DRB Application No.: 07DRB-70205 (P&F)

Project Name: LIVINGSTON PLACE  
SUBDIVISION NO. 2

**CITY OF ALBUQUERQUE  
Planning Department  
August 29, 2007  
DRB Comments**

**RE: Lots 1, <sup>2</sup>2A, 2 & 18, Block A, Livingston Place Subdivision  
No2/minor plat**

**PLAT OF
LOTS 1-A AND 2-A-1
BLOCK "A"
LIVINGSTON PLACE SUBDIVISION No. 2**
WITHIN
TOWN OF ATRISCO GRANT
PROJECTED SECTION 5, TOWNSHIP 10 NORTH, RANGE 3 EAST, N.M.P.M.
CITY OF ALBUQUERQUE, BERNALILLO COUNTY, NEW MEXICO
AUGUST, 2007

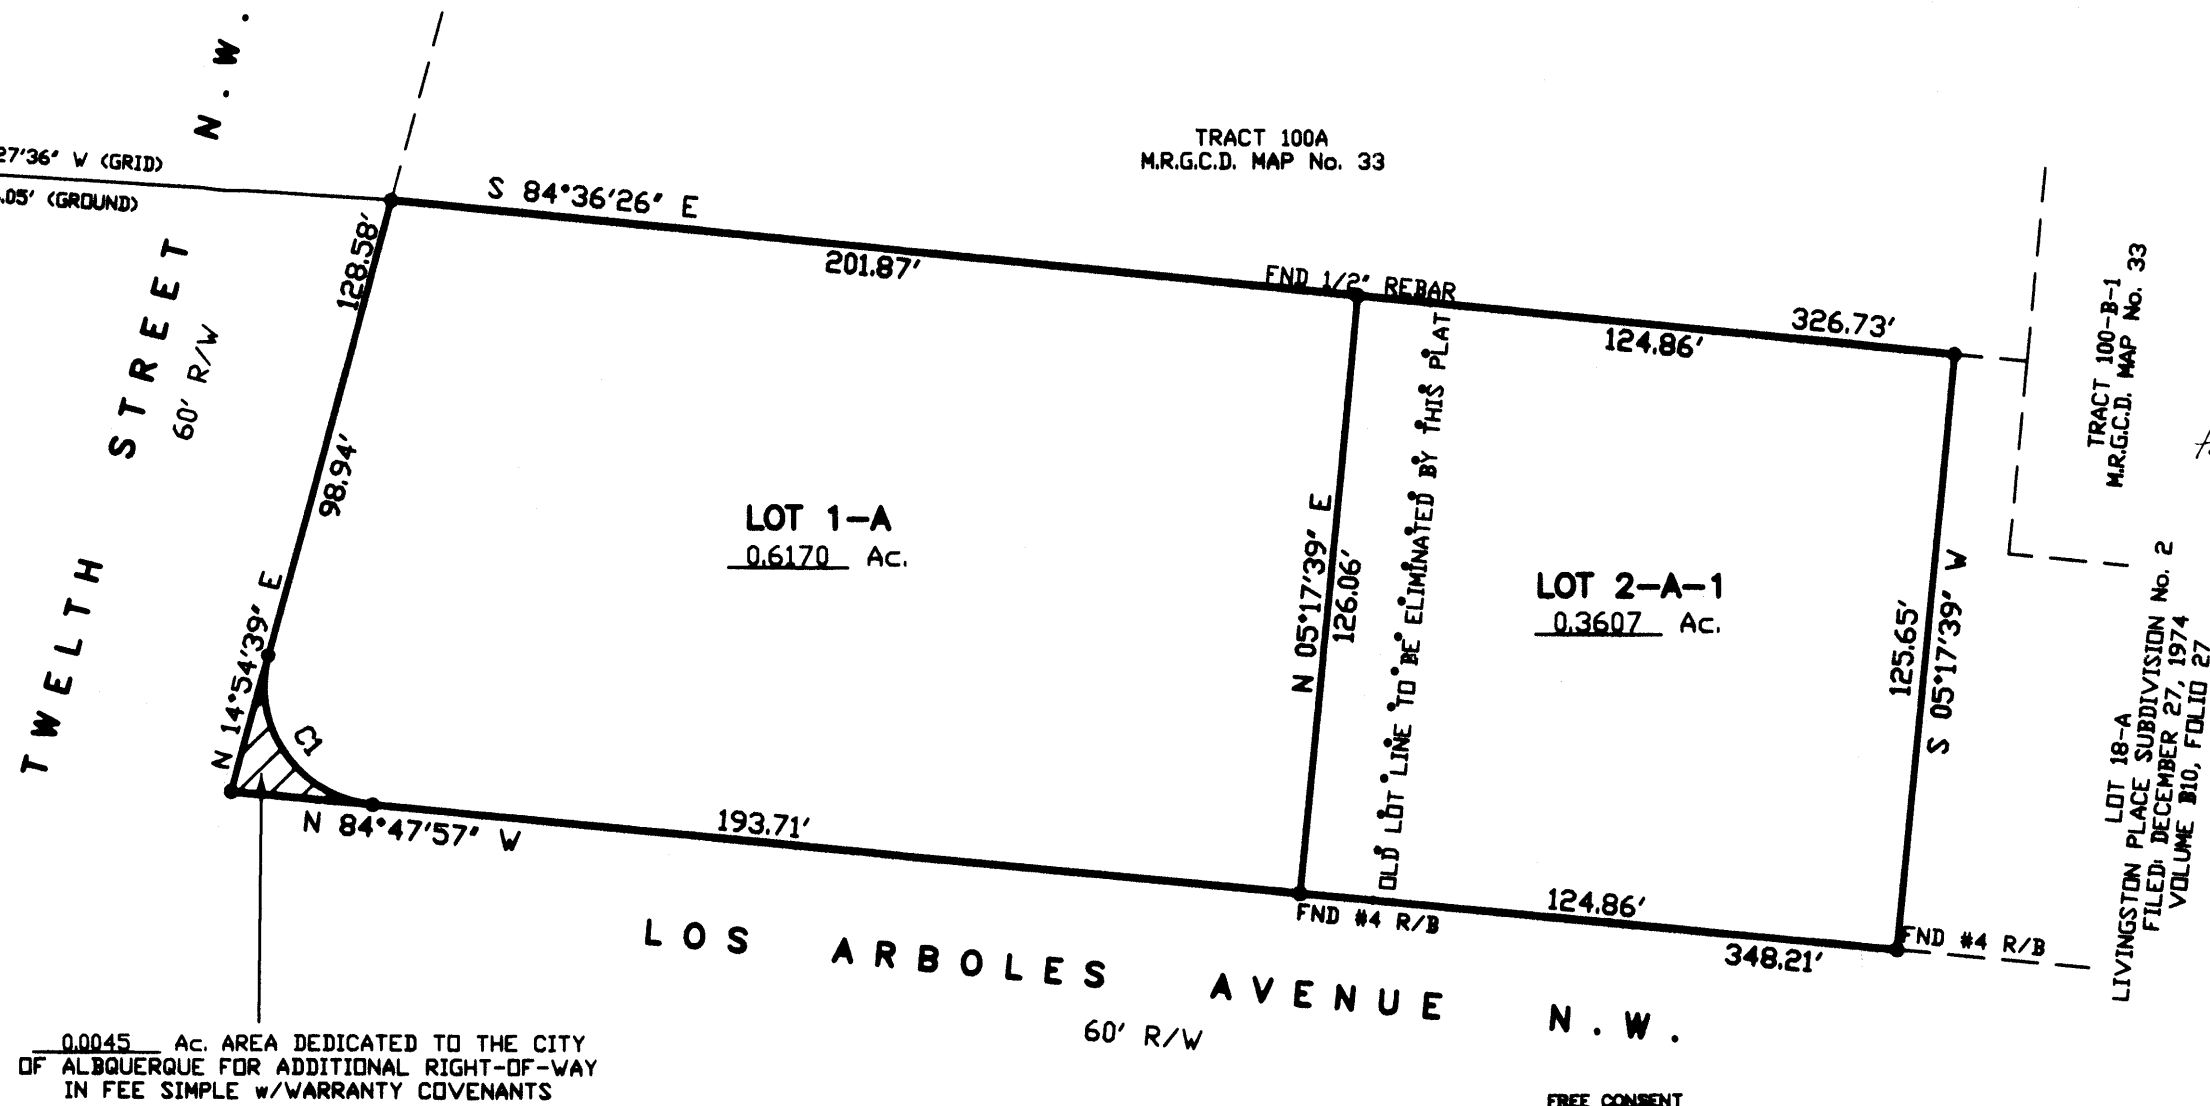
TRANSPORTATION: Sidewalk on Los Arboles NW

Be sure the solar collector language is on the plat. We will take delegation for the this, to record the plat & for AGIS dxf approval.
